Application Number 2021/93621

Land off, Fullwood Drive, Golcar, Huddersfield HD7 4JH

Erection of 10 dwellings and associated works (Within a Conservation Area)

I would like to object to the above Planning Application:

Description: PROPOSED SITE PLAN & 3D VIEW

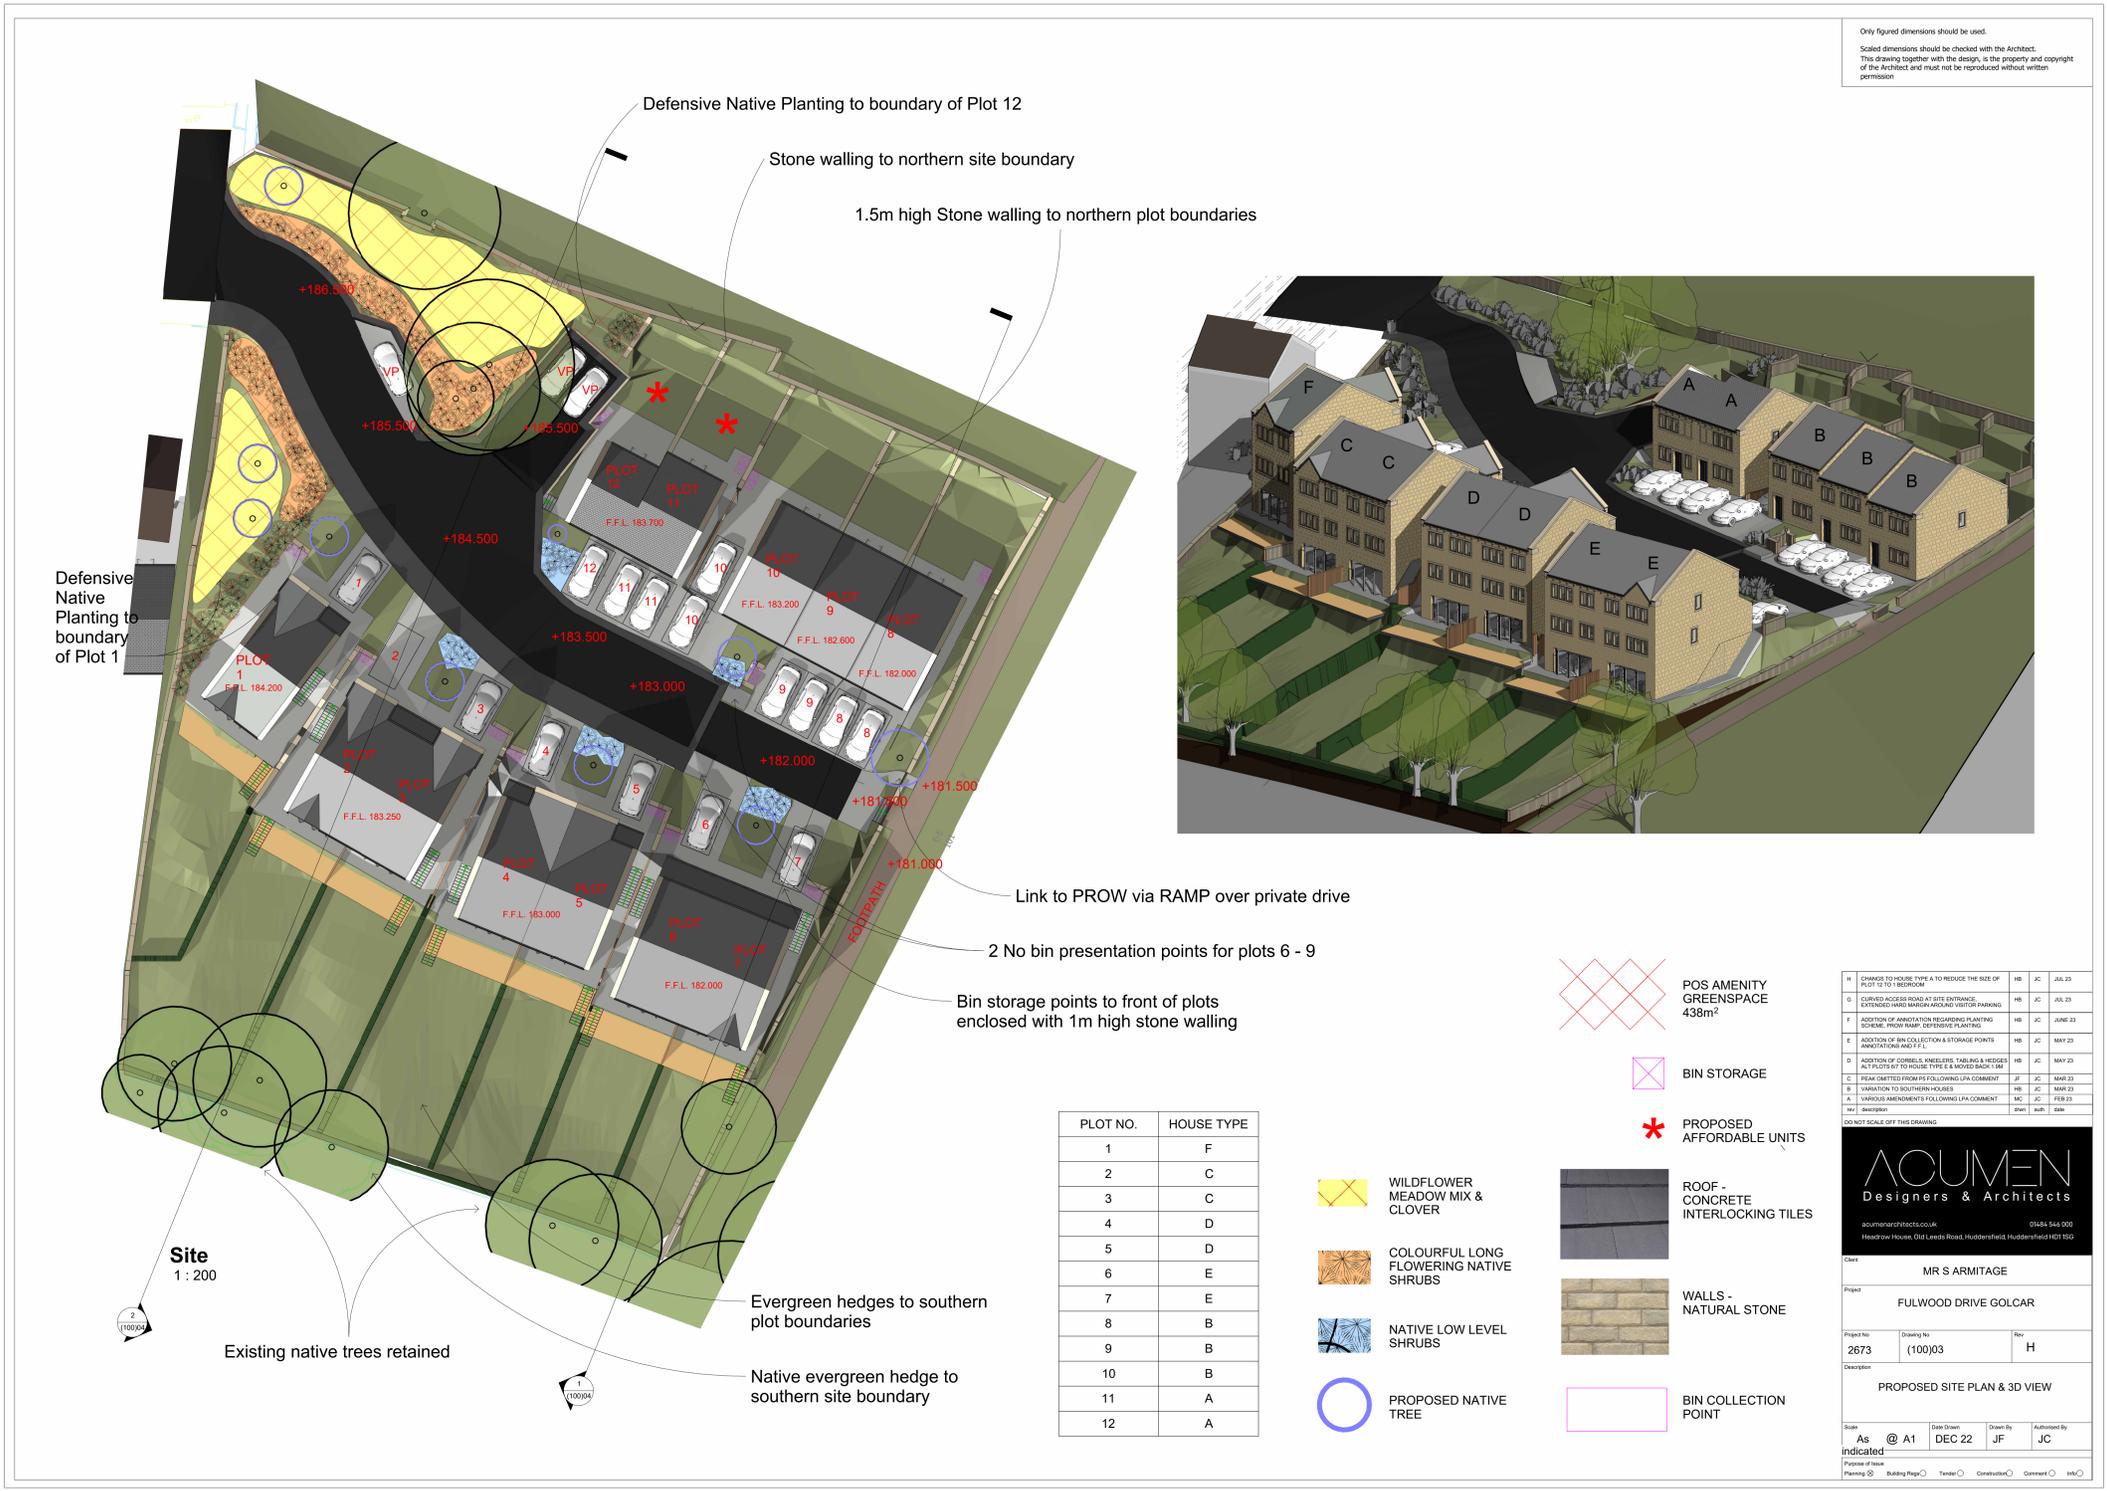
This planning application shows the roadway continuing through this estate of new houses from Carr Top Road up to Fullwood Drive, which was designed as a cul-de-sac and families have for 40 years allowed their children to play out in safety. Any attempt to use the cul-de-sac as an access road would be entirely unsuitable and dangerous. There could potentially be a further 100 plus cars using this cul-de-sac every day. The road is single track and impassable if householders park outside their homes. Also the road surface was not laid to be a main road and is off Victoria Lane which is very steep.
